Powell Amenity Center
212 Perseus St. Lillington, NC

Attn: Harnett County Environmental
RE: Plan Review Comments

1 POOL LAYOUT PLAN
 SP2.0
 1/8" = 1'-0"

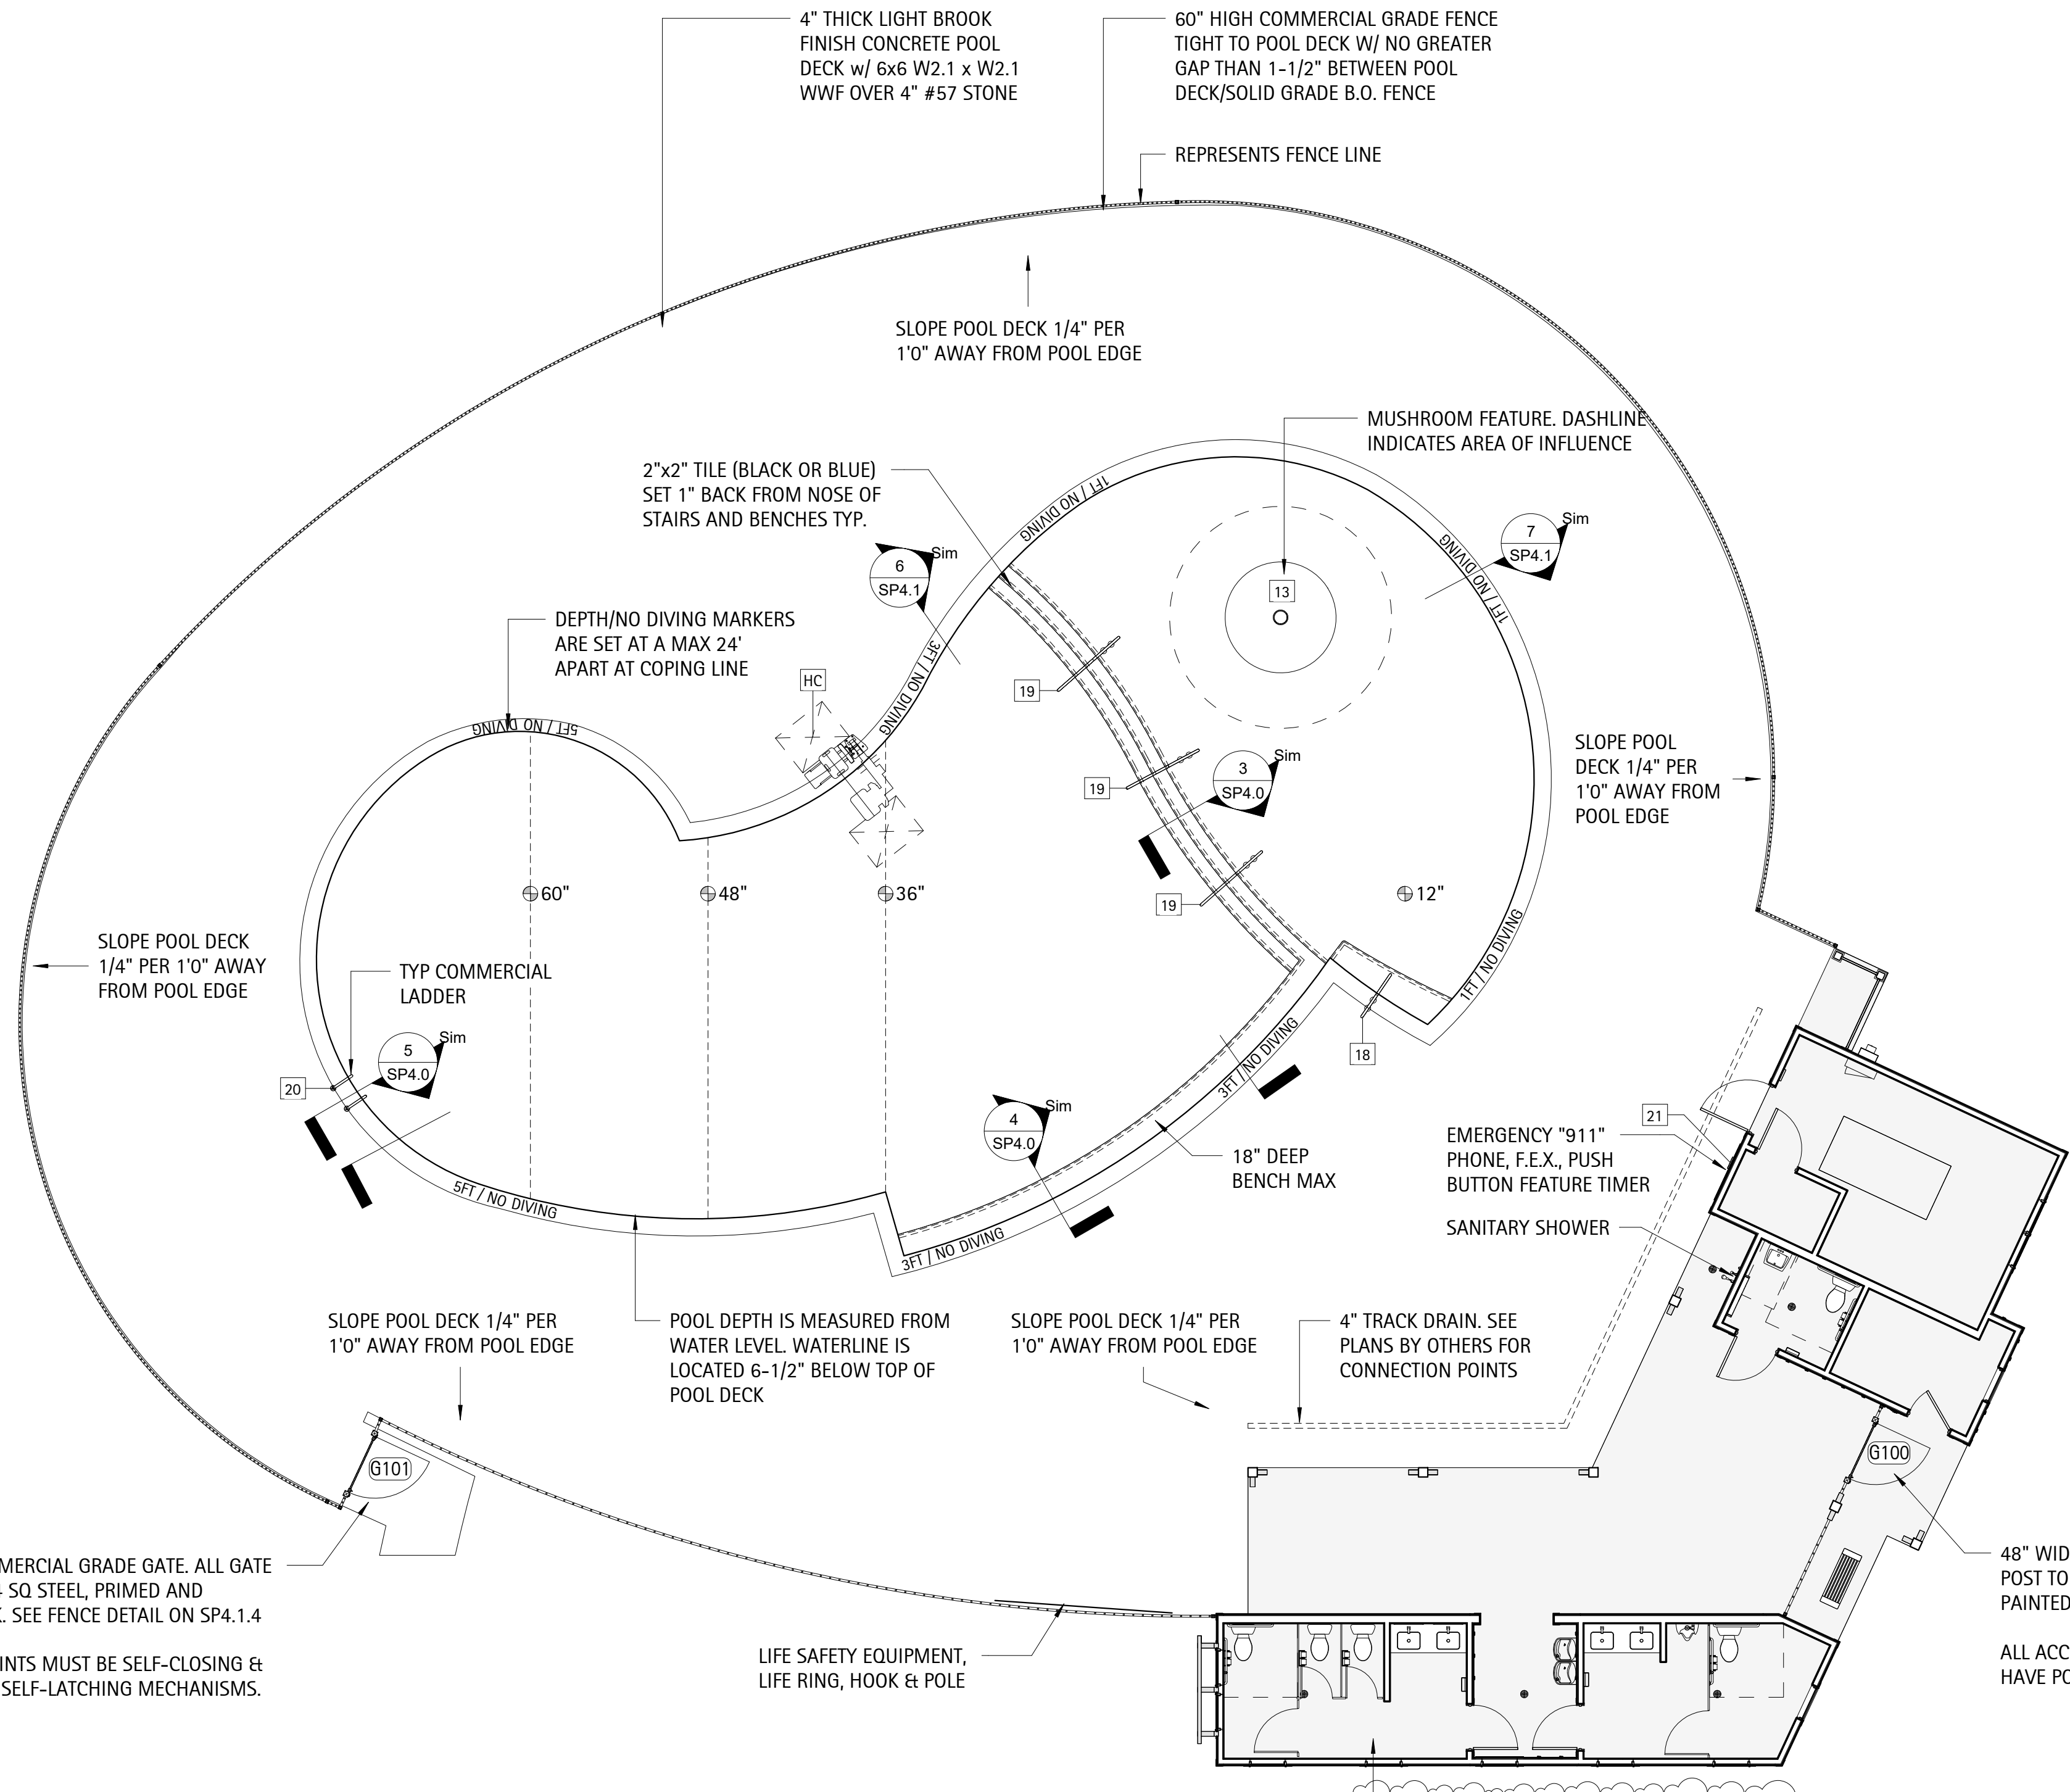
- Comment 3: Specify pool color finish.
 - **Pool plaster specification has been added to this document.**
- Comment 4: Indicate if flooring in the restrooms is slip resistant: plans specify a smooth finish.

- **This notation is incorrect. I have added additional notations to the pool plans stating that the restroom flooring is to be slip resistant. See SP2.0 for changes.**

SP3.0

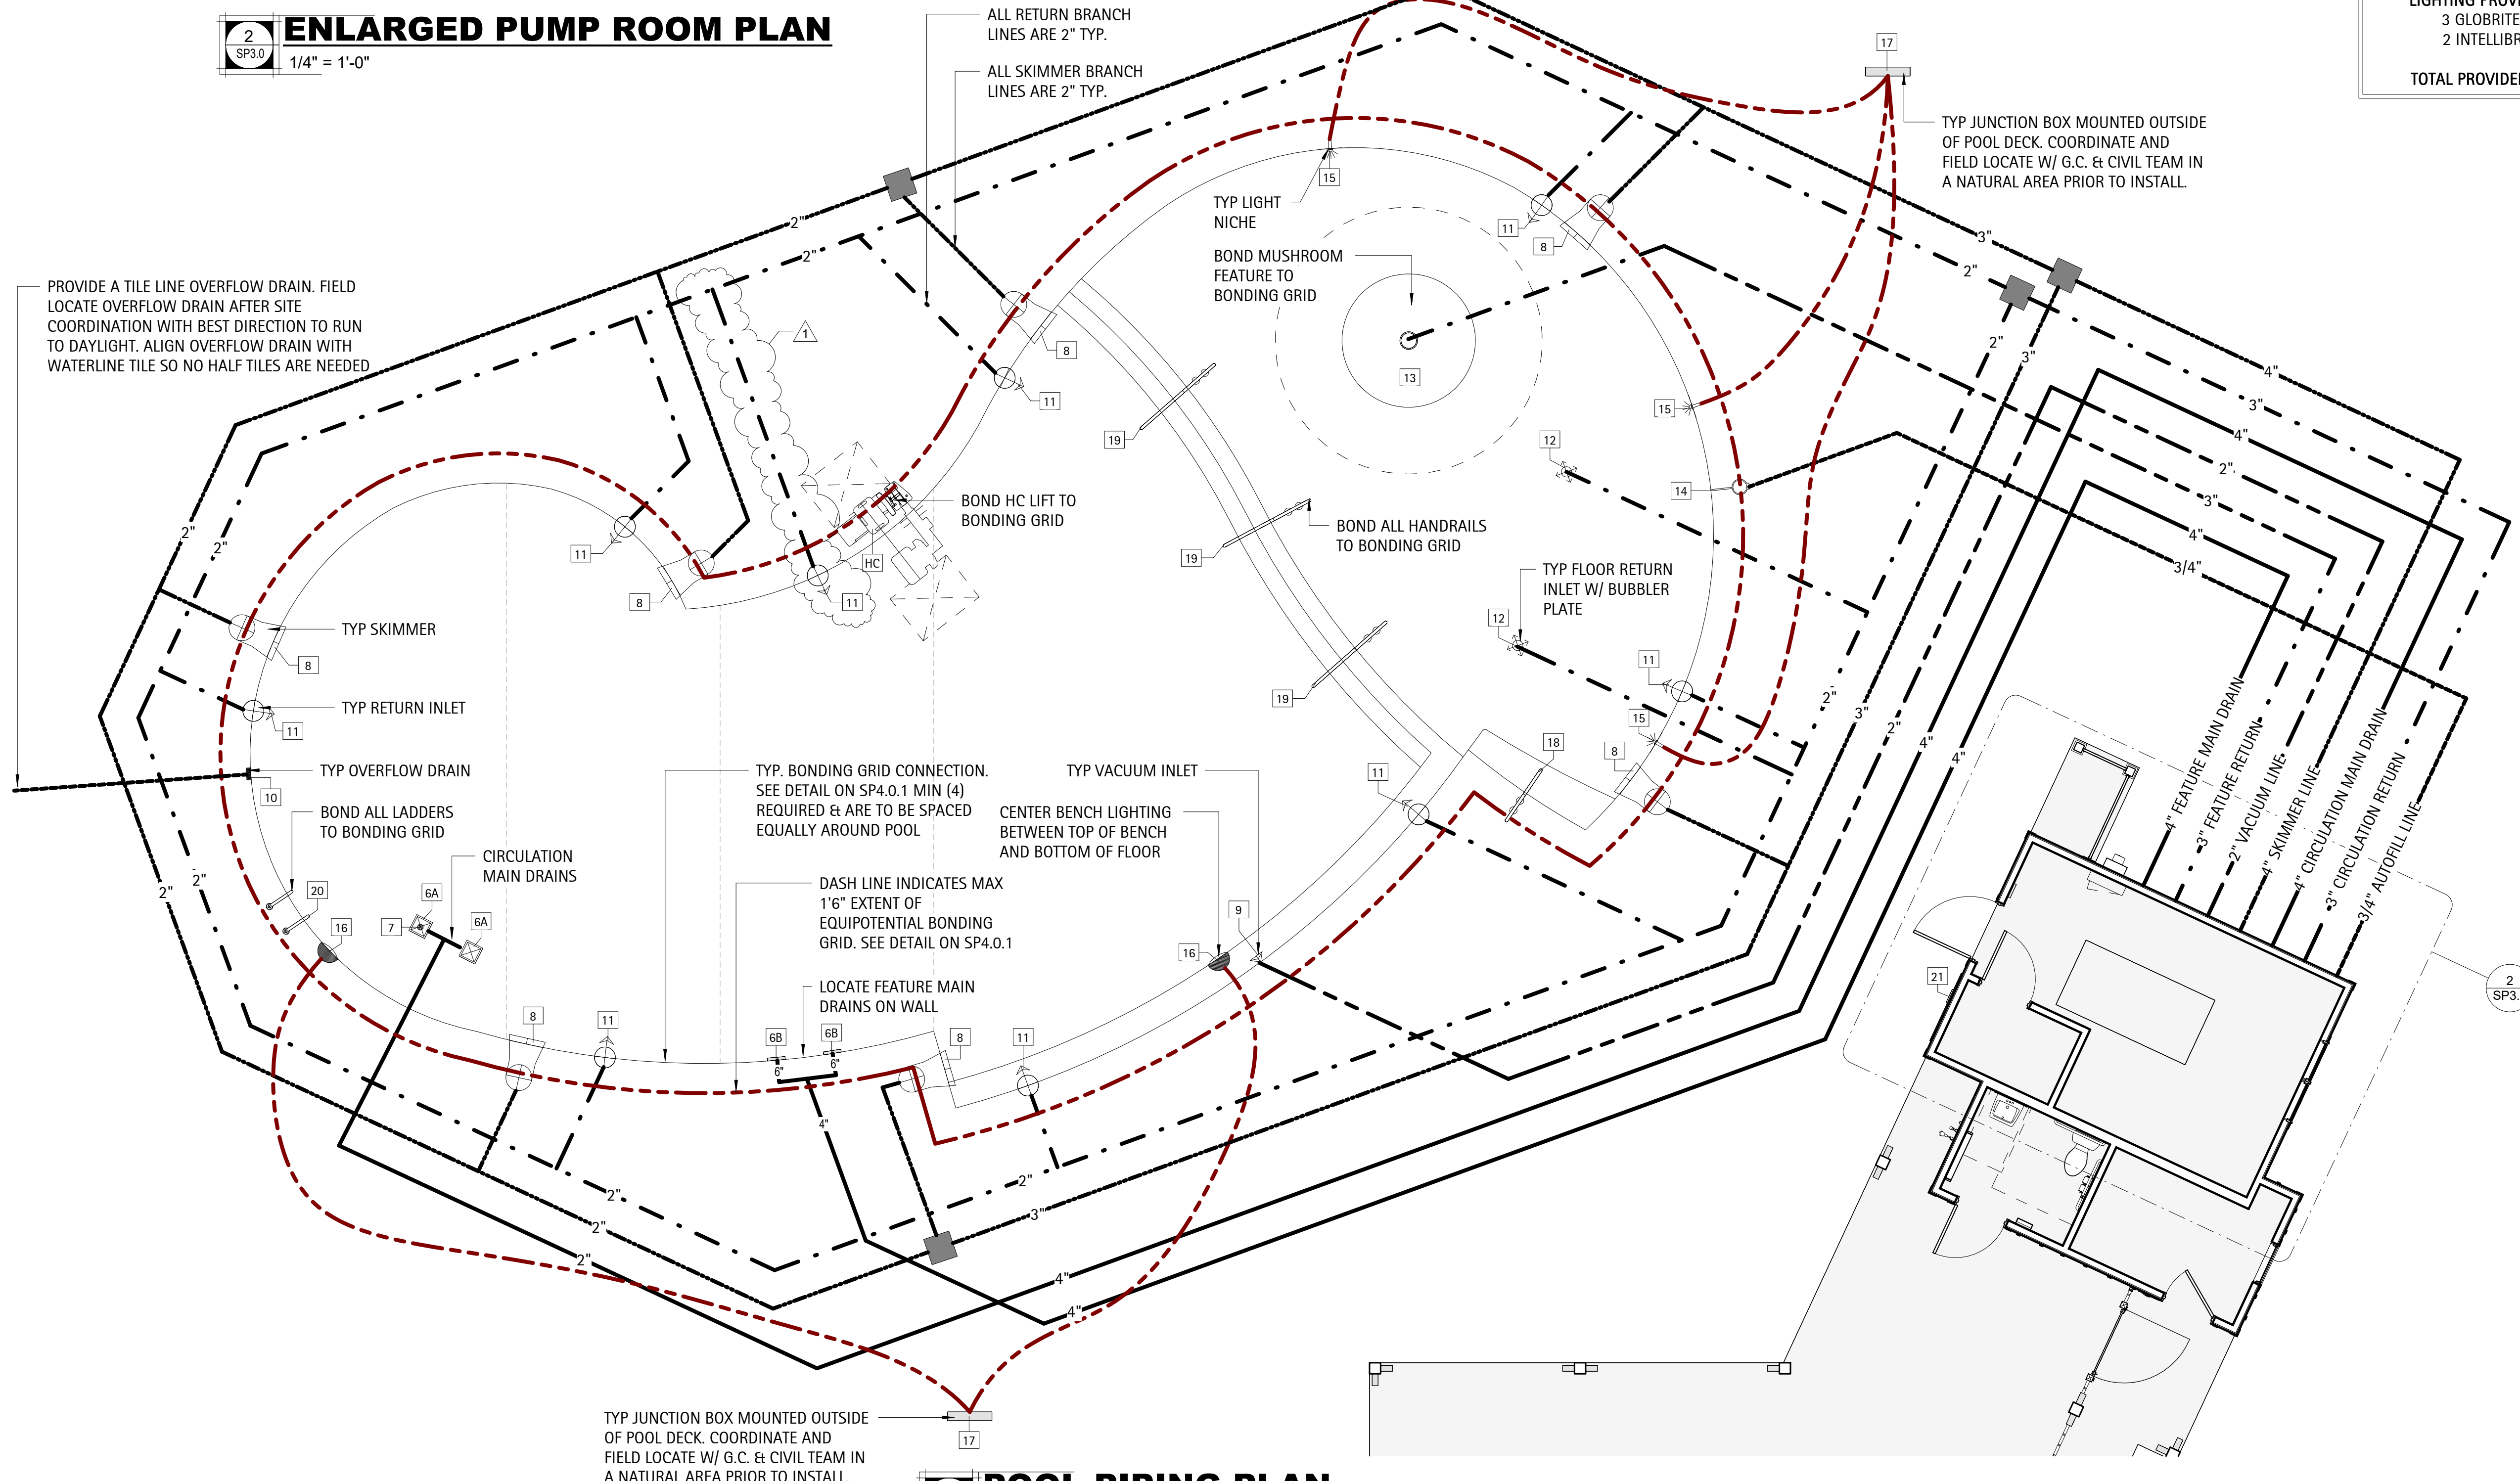
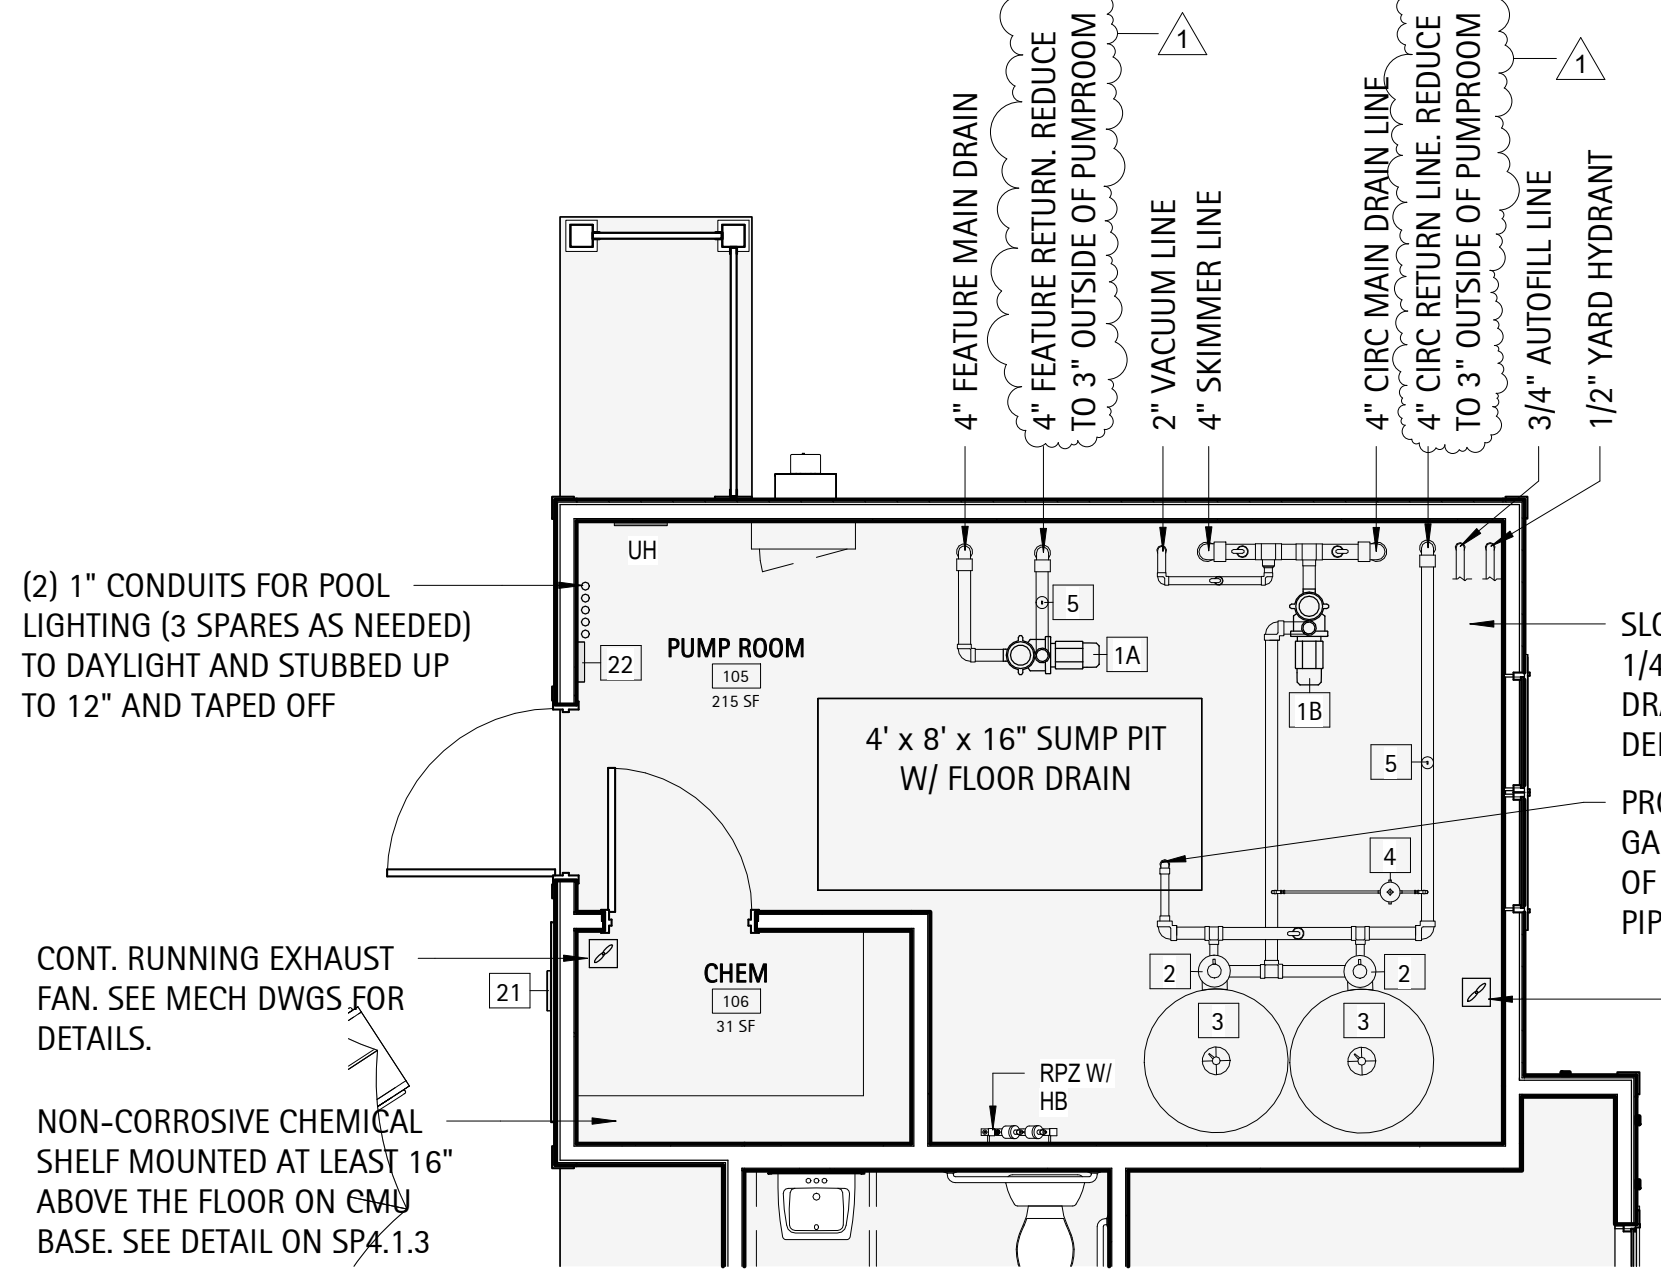
- Comment 1: An inlet located to the left of the handicap lift chair as viewed from above, is shown connecting to the suction piping on page SP3.0, piping & electrical diagram.

- **This was an error and has now been corrected. See SP3.0 for changes.**
- Comment 2: The flow meter specified appears to be undersized. The design flow rate of 190 GPM would be 275 GPM at 1.5x. The specified flow meter is rated for up to 240 GPM.

- **Flow meter has been upsized to a 4" flow meter along with the return piping. Return piping will reduce back to 3" outside of the pumproom as noted on plans. See SP3.0 for changes.**
